OUT17/9241

**Eastern Creek Energy from Waste Facility (SSD 6236)  
Comment on the amended Environmental Impact Statement (EIS)**

| BASIN SUMMARY | | | | |

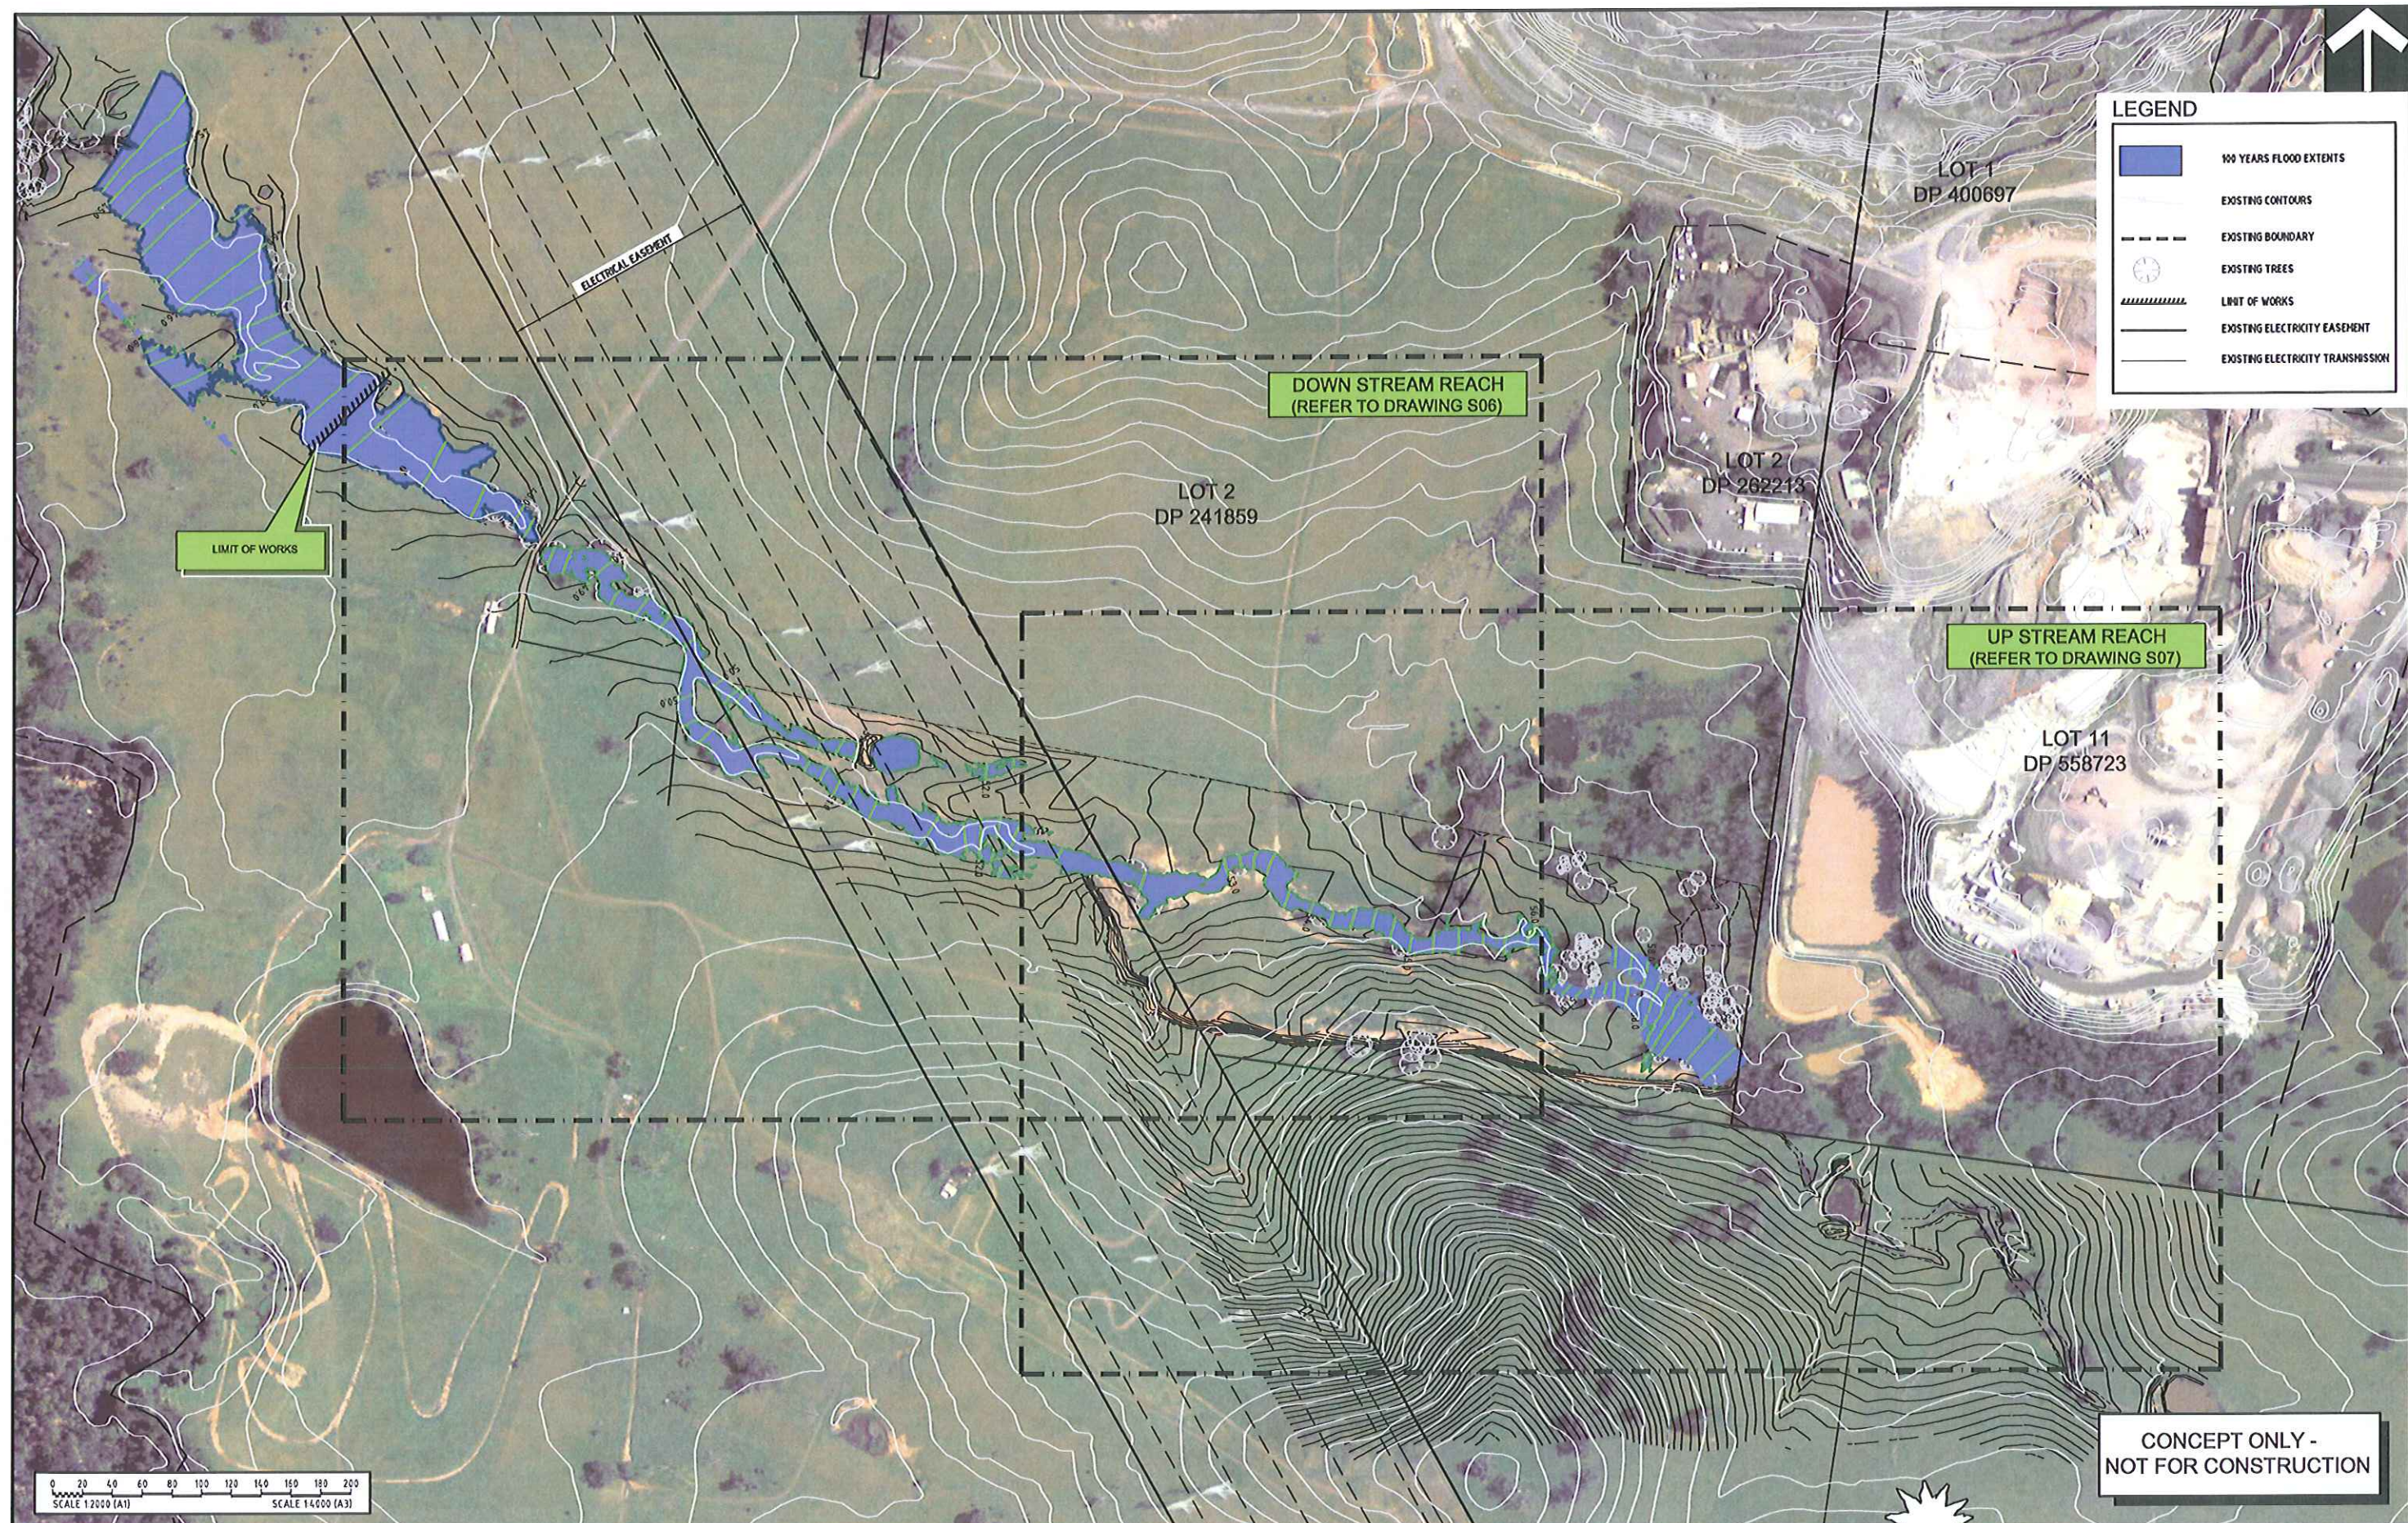
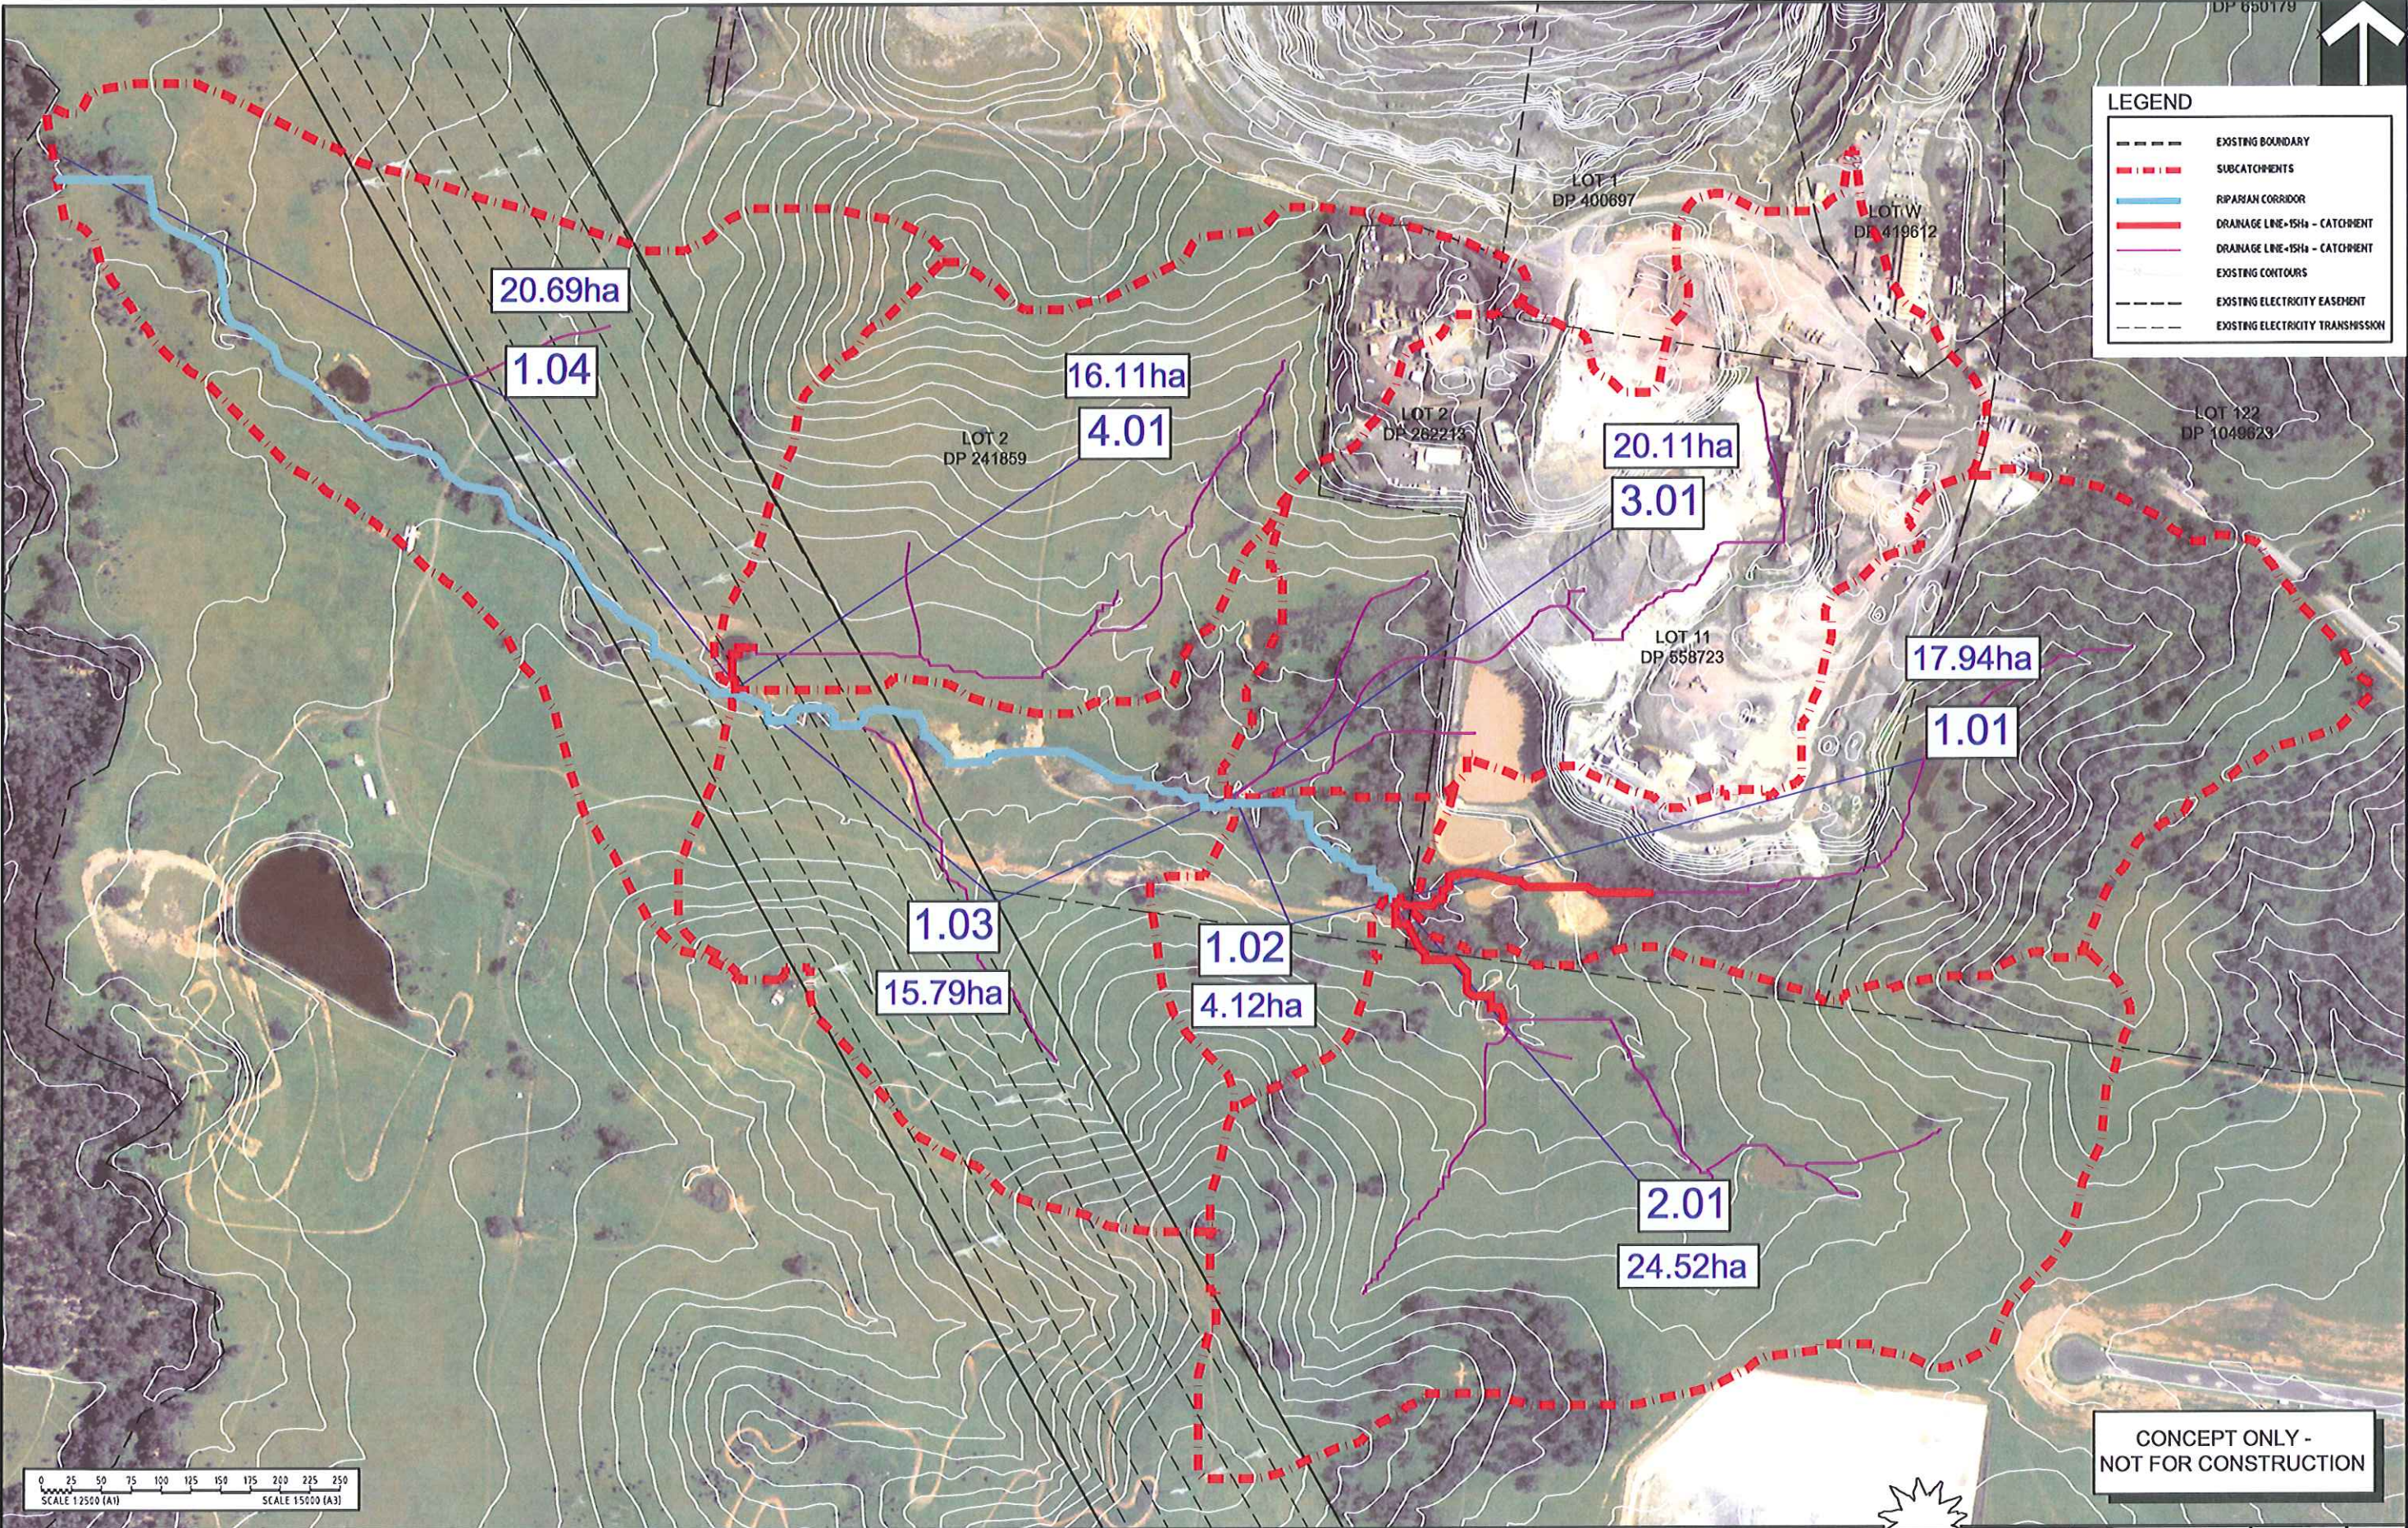
- The proponent should provide further details regarding the potential salinity impacts of constructing the basin in the riparian corridor if high salinity levels are found in the area.
